# ENG-SF20028-R1-GEC.pdf Markup Summary

**Subject:** Text Box  
**Page Index:** 1  
**Date:** 12/30/2020 12:43:11 PM  
**Author:** dsdrice  
**Color:** ■  
**Layer:**  
**Space:**  
**Page Label:** [1] 1 2514901CV01 - CV01

PCD Filing No.:  
SF-20-028

URBAN COLLECTION AT PALMER VILLAGE	SWALE CROSS SECTIONS	GEC PLANS
SHEET 3 OF 10	JOB NO. 25149.01

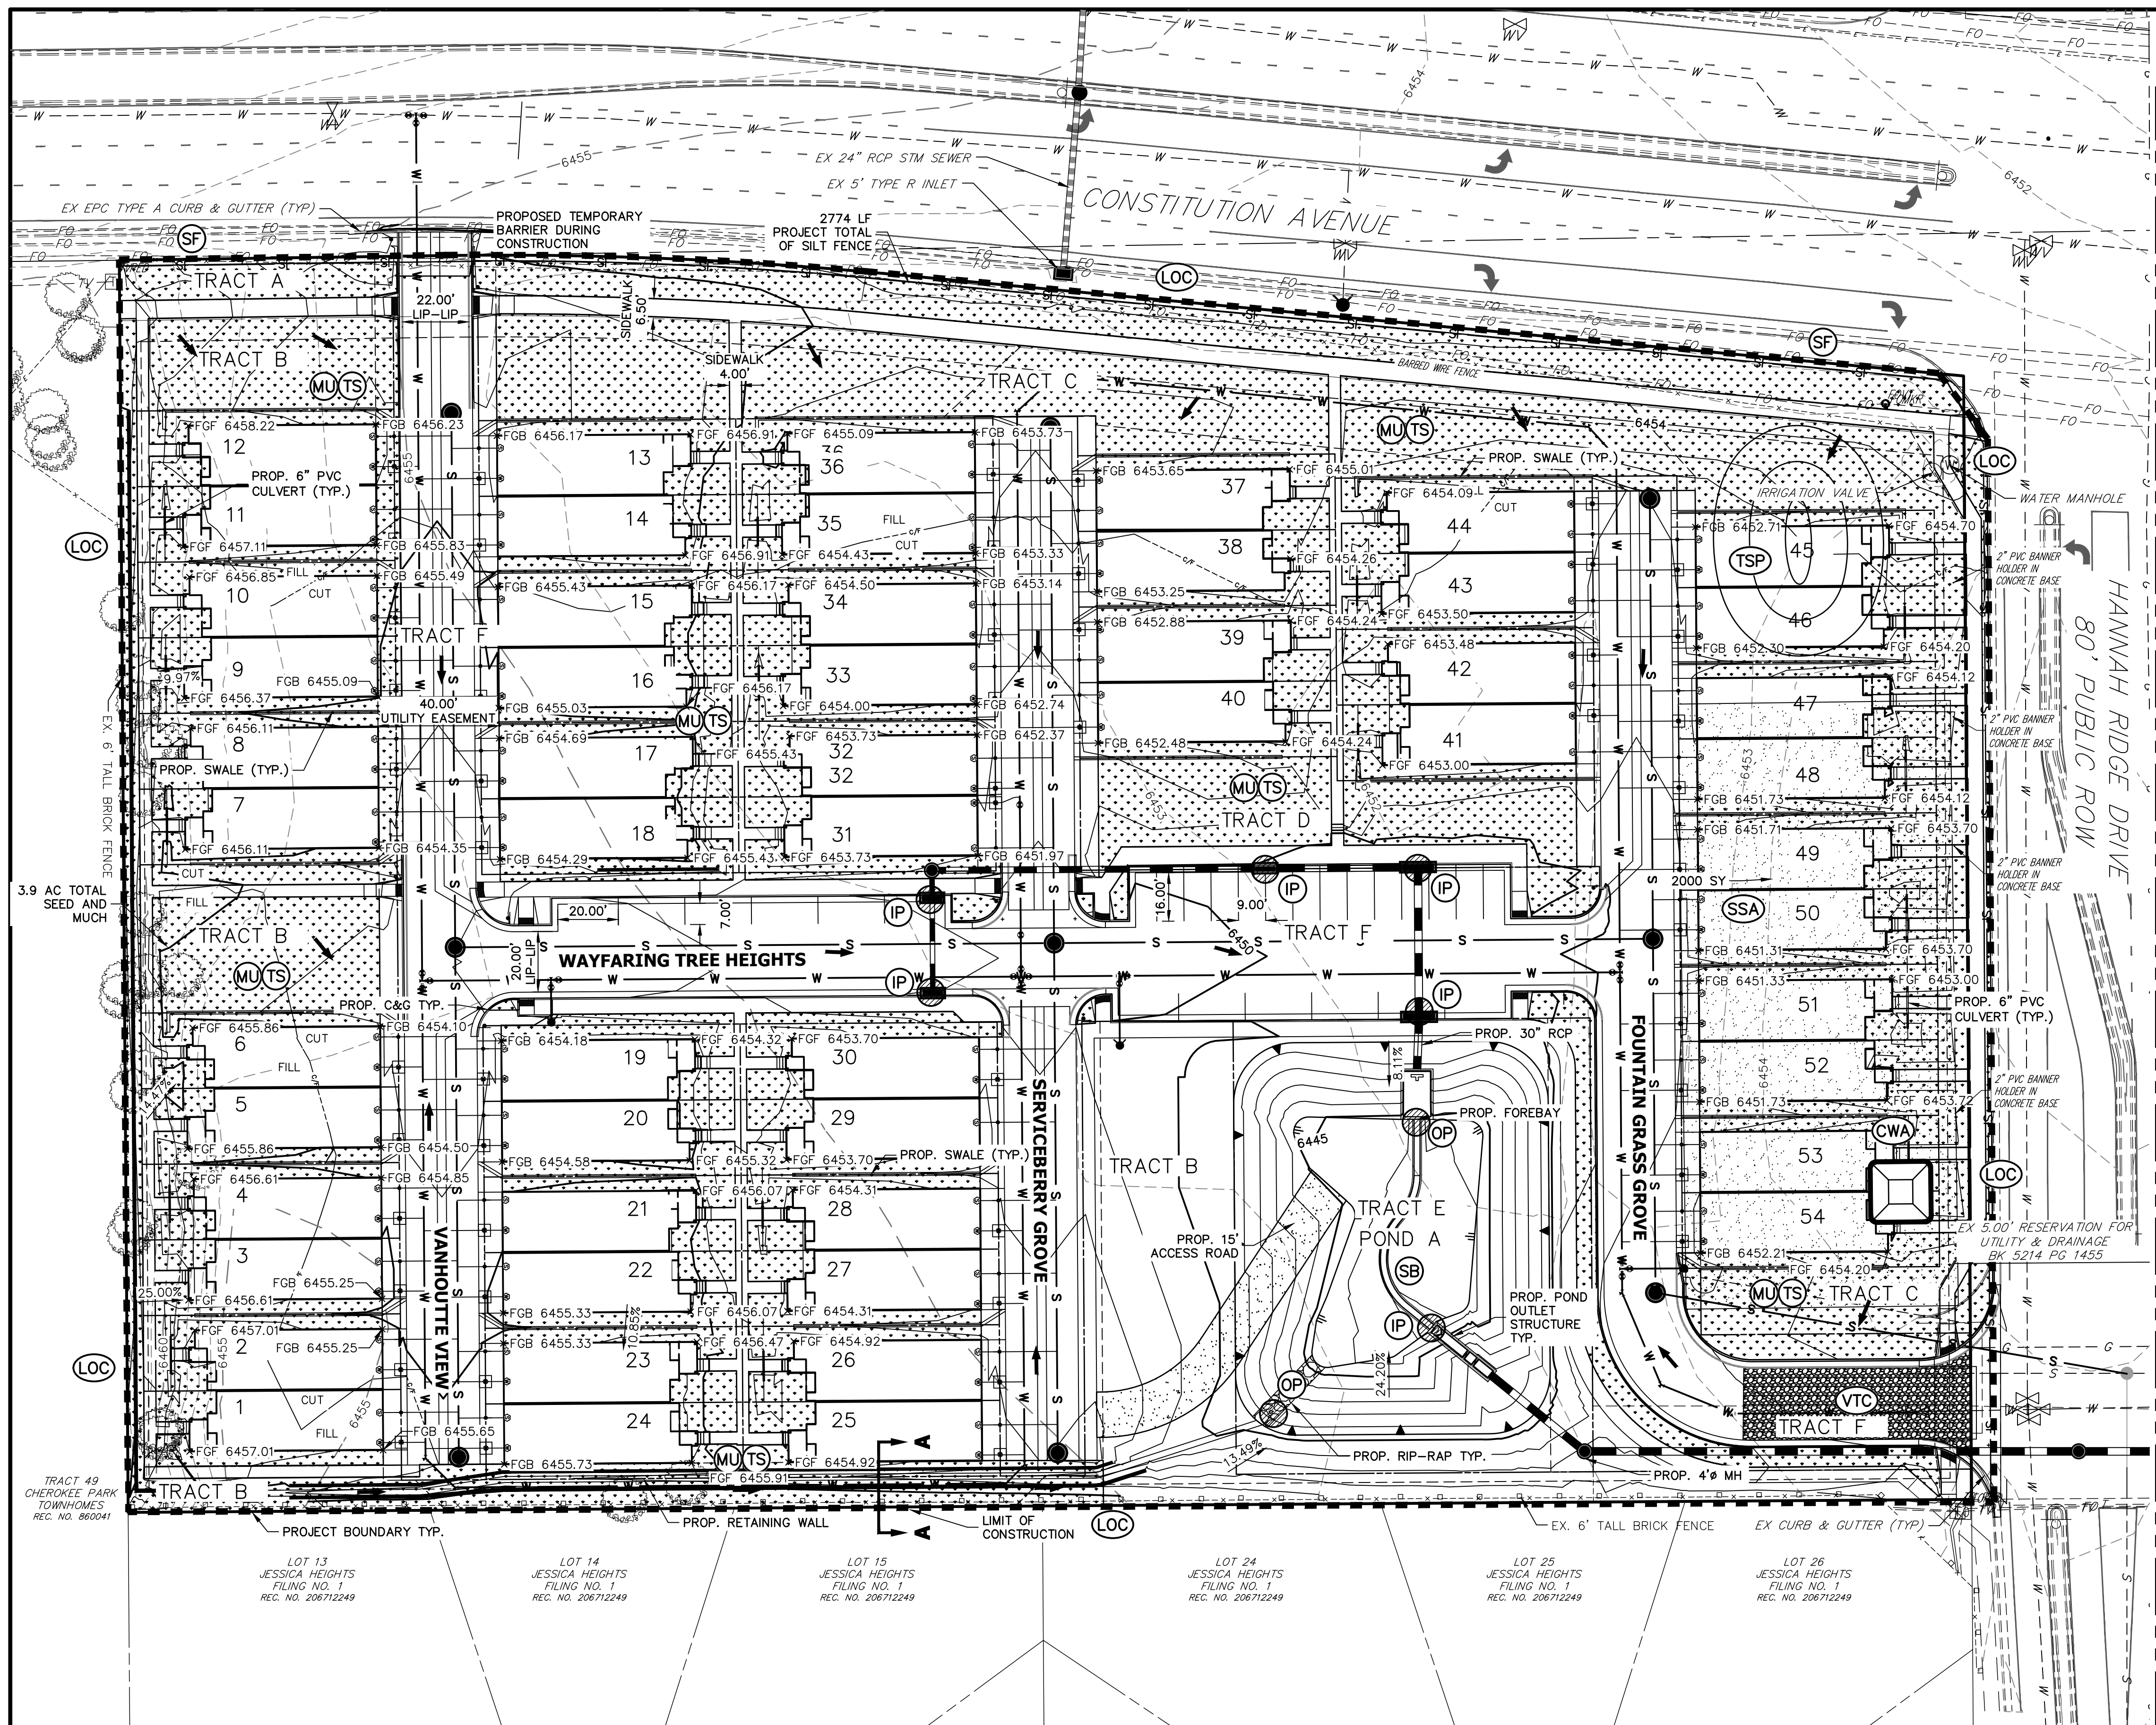
Provide cross-sections of swales.

Provide cross-sections of swales.

811
 URBAN COLLECTION AT PALMER VILLAGE
 EROSION CONTROL PLAN
 GEC PLAN

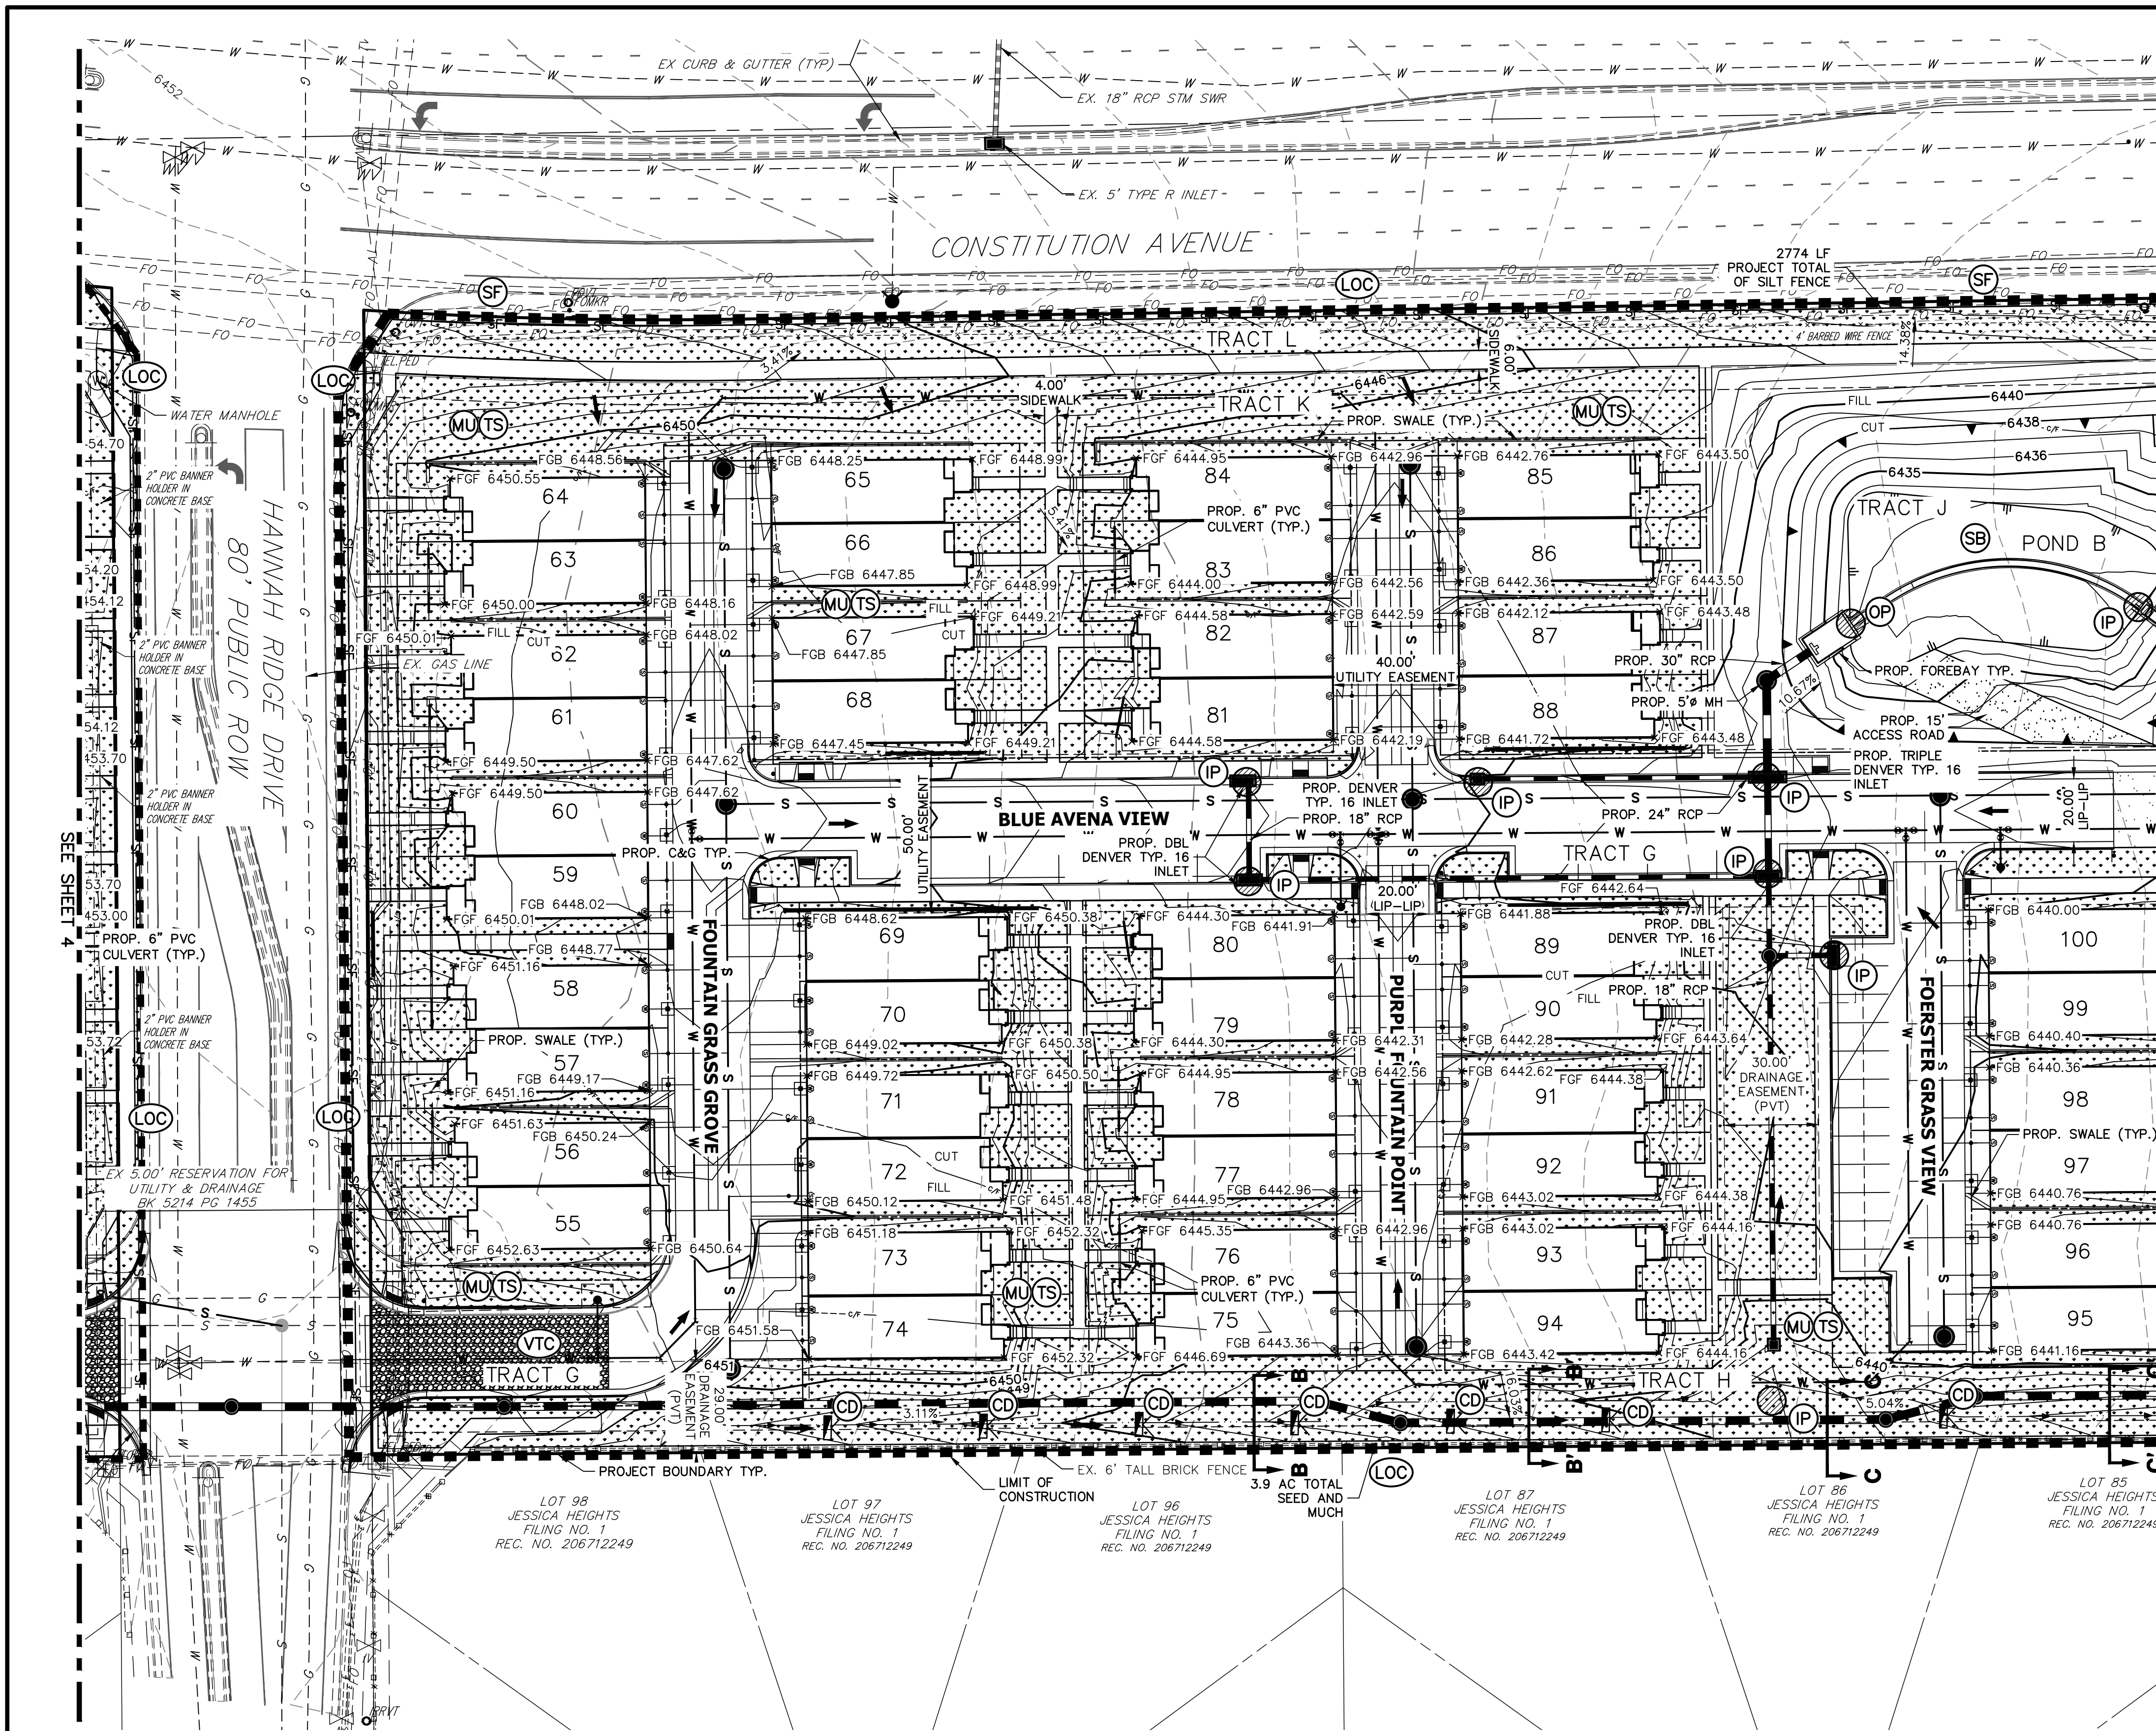
Access ramp shall be a minimum of 15 ft wide, in accordance with DCM Vol. 1 Section 11.2.2

label as Pond A

Checklist Item "v" --- include a note or a table that labels/lists each BMP as initial, interim, and final.

Or add a note that states that there will not be phasing for this project.

Checklist Item "i" --- include a note about existing vegetation

URBAN COLLECTION AT PALMER VILLAGE
 EROSION CONTROL PLAN
 GEC PLAN

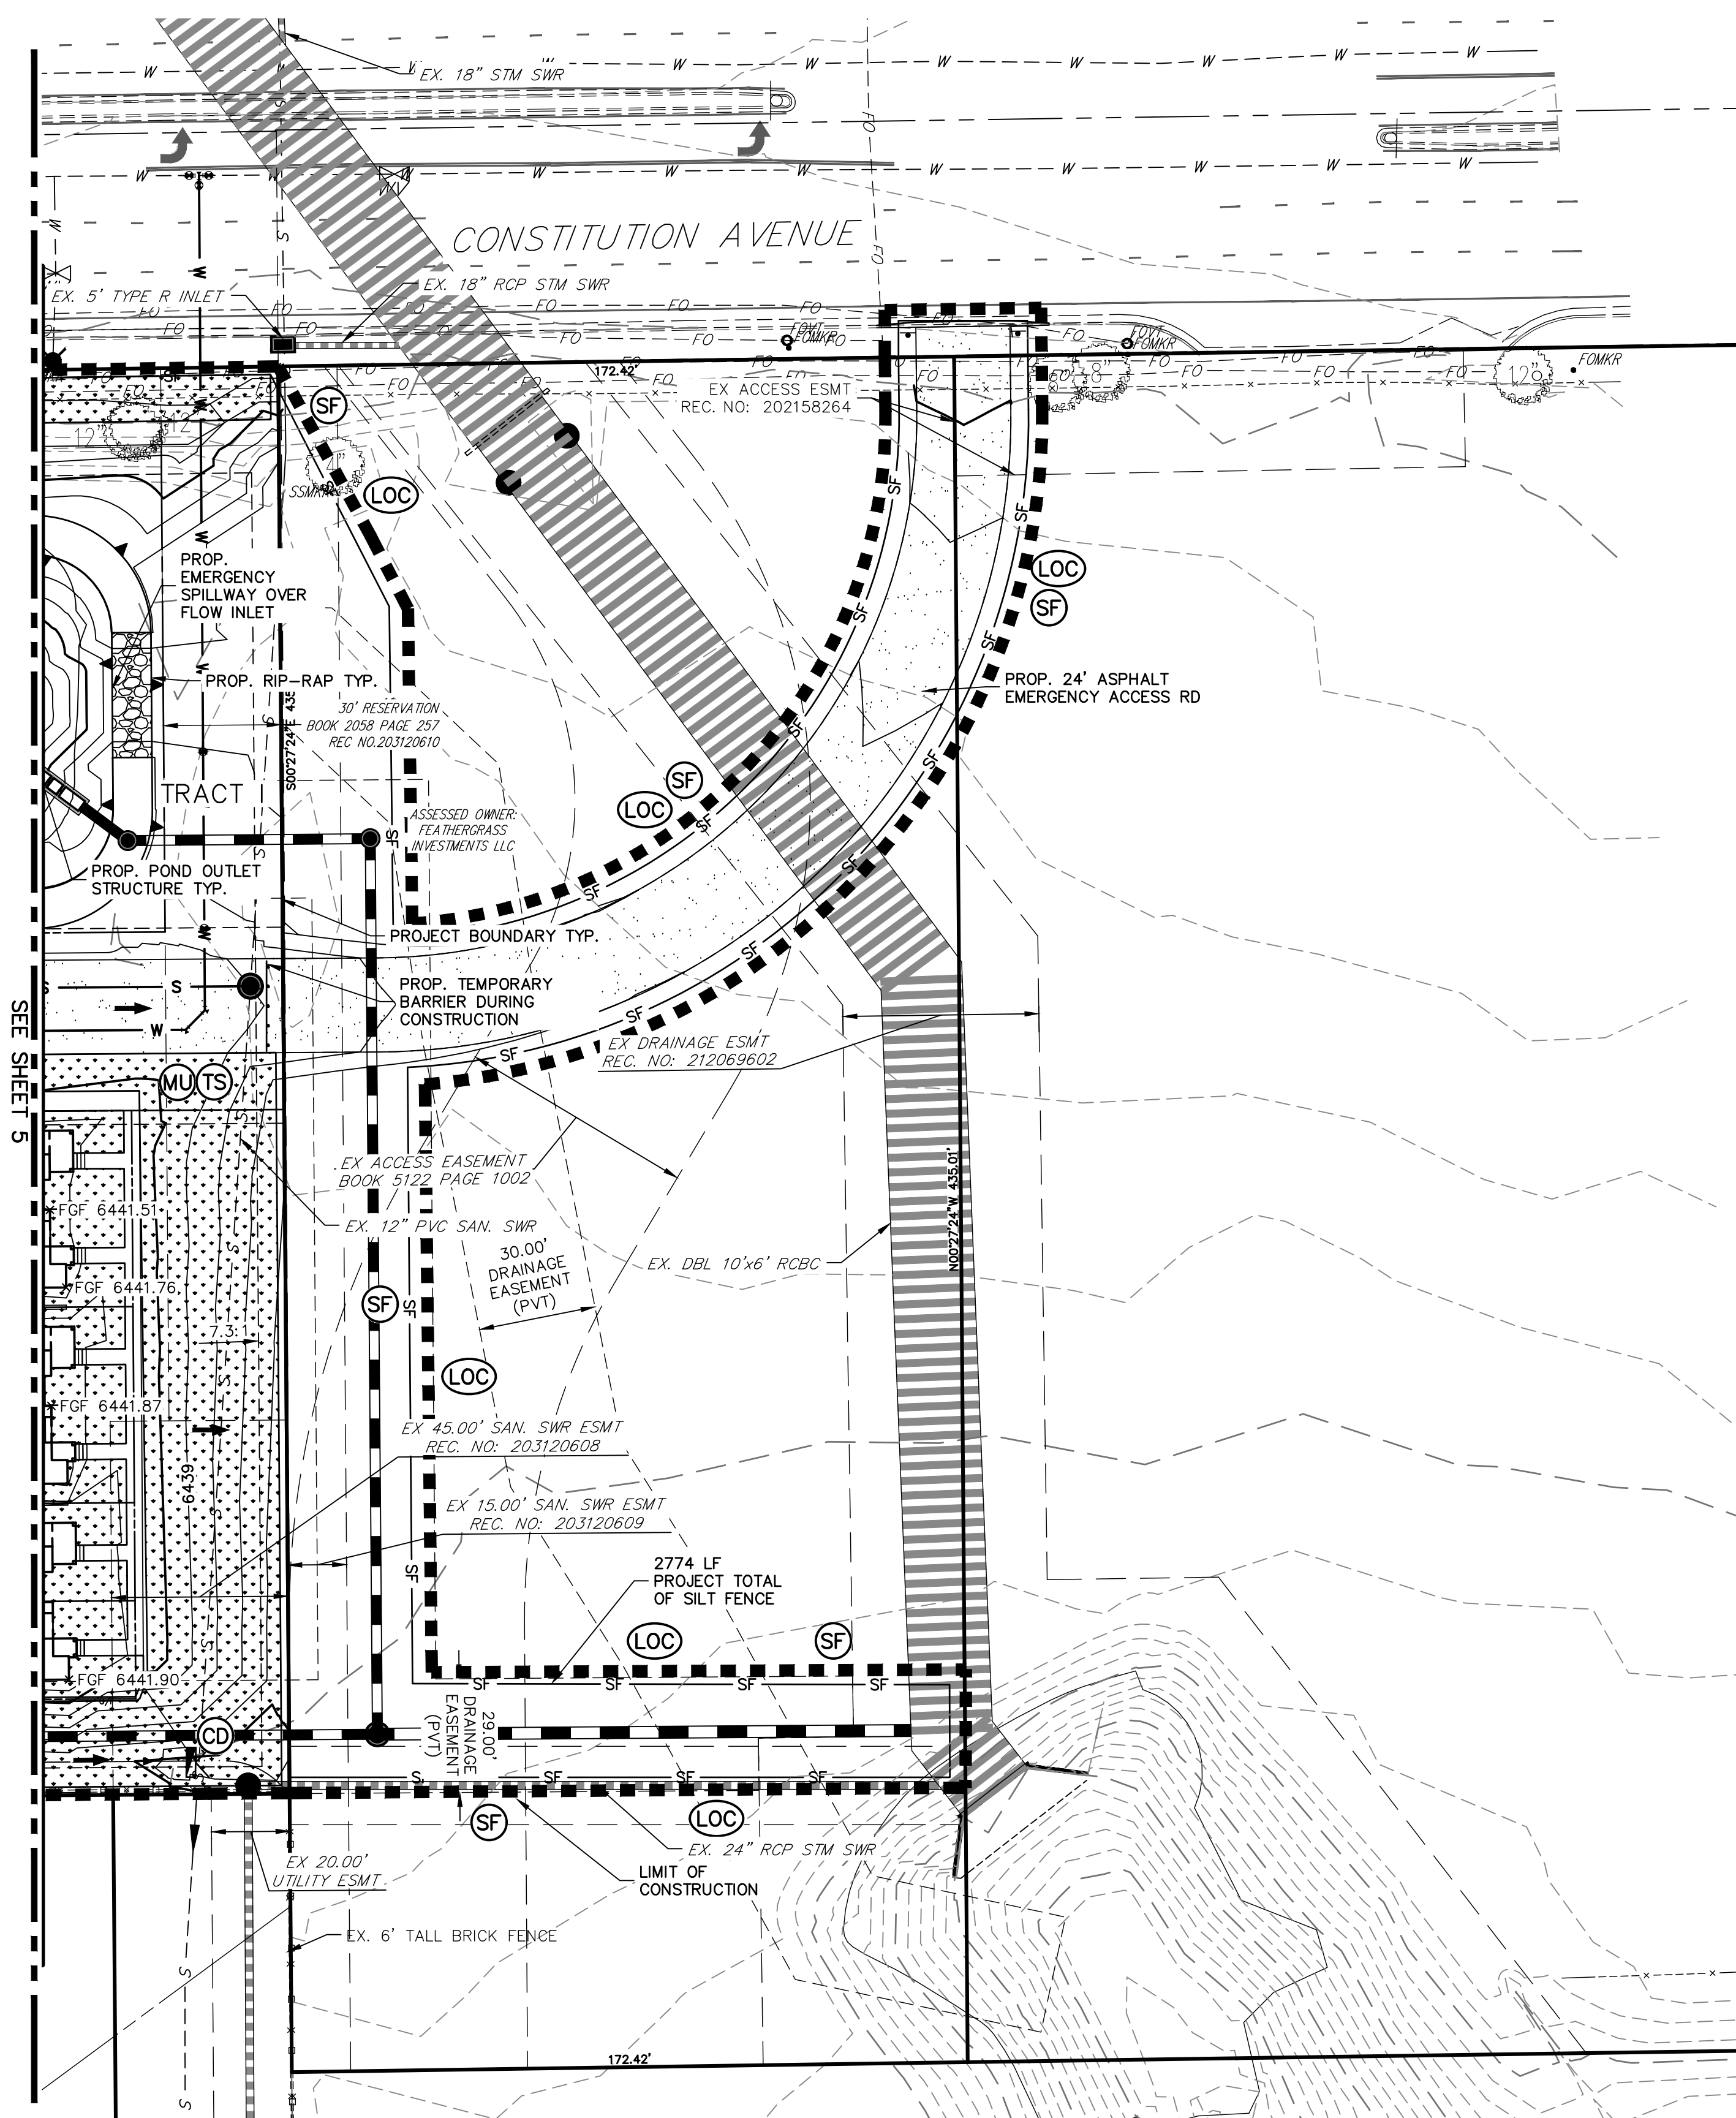
Look at the checkdam detail and increase quantity accordingly, per the height of the dam and the 2-yr storm. Likely should be spaced a lot closer than this.

Not seen on plans. But if there is a possibility that it is used on the site, include a detail on the last sheet.

Access ramp shall be a minimum of 15 ft wide, in accordance with DCM Vol. 1 Section 11.2.2

label as Pond B

Label this type of hatching with text callout or include in Legend.

Provide detail on last sheets.
